**REF: 23/01496/DISC****Location: Proposed Himley Village North West Bicester,  
Middleton Stoney Road, Bicester**

21 July 2023

Thank you for consulting me on the above application. I have reviewed the submitted design code for this development. I have some concerns with the proposals where details are incorrect or missing, and for that reason I am unable to support this application in its current form. This objection may be addressed by amendments and submission of further information which addresses my comments below.

PRIMARY SCHOOL

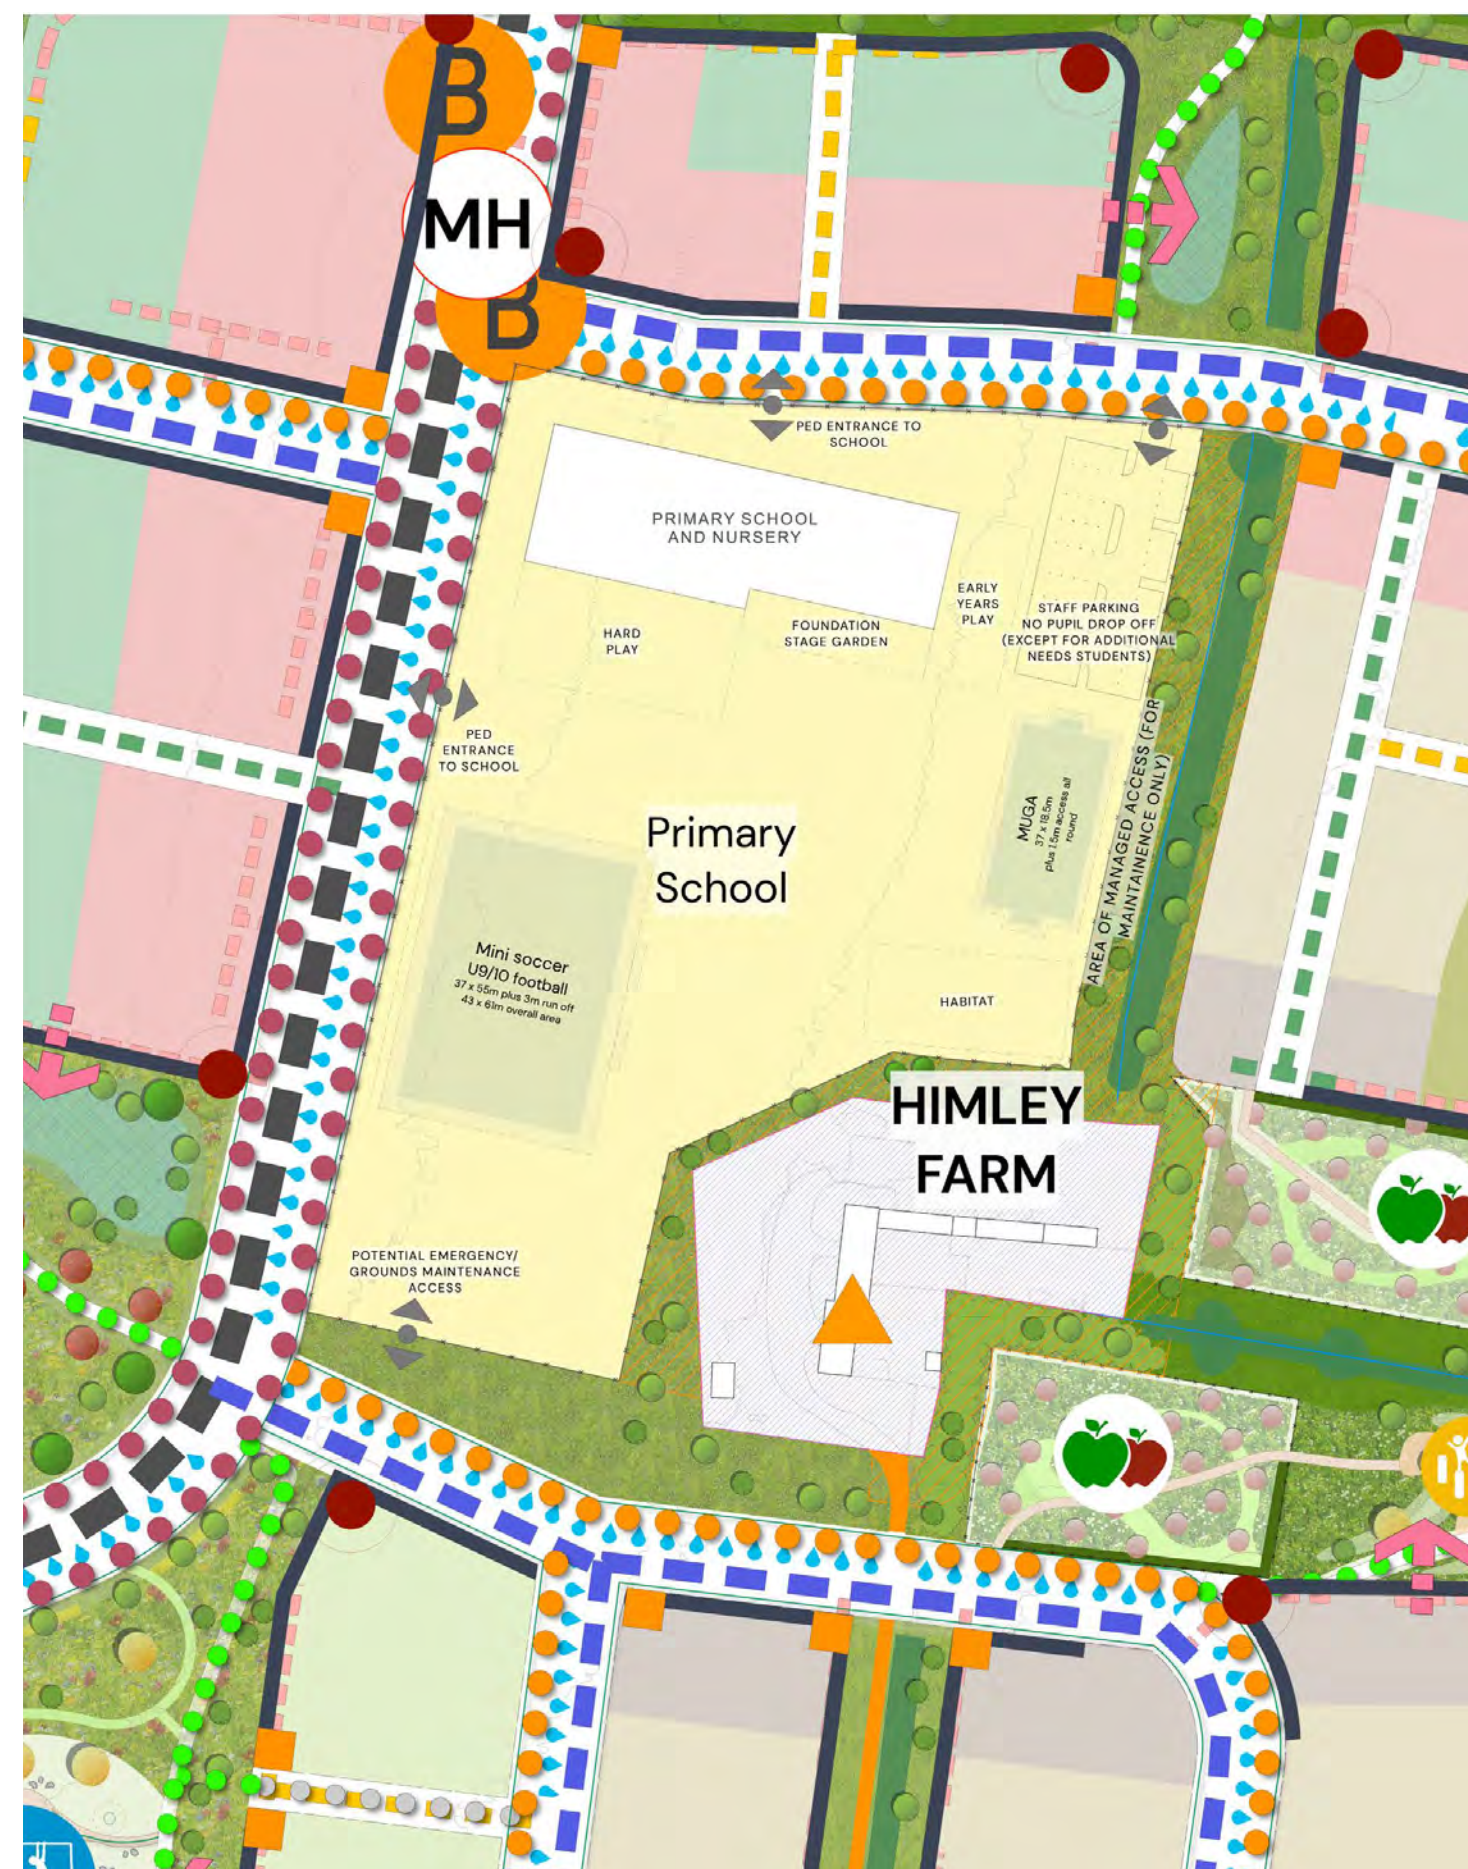
- Page 1.3 – Primary School point 5 – I note no drop off is provided, however it is vital that the surrounding street networks are able to cope with drop offs by vehicles. Whilst sustainable travel is desirable, it is inevitable that a number of pupils will be dropped off and picked up by vehicles every day. If residential use is adjacent to the school there is a high risk of disputes and community tension whereby parents may park inappropriately blocking residential access and parking to drop off/pick up children. It is worth considering providing other community uses with car parking close by, such as a community centre or similar whereby the car parking for these facilities could be used for easy drop off and pick up without blocking roads and creating a demand on policing.
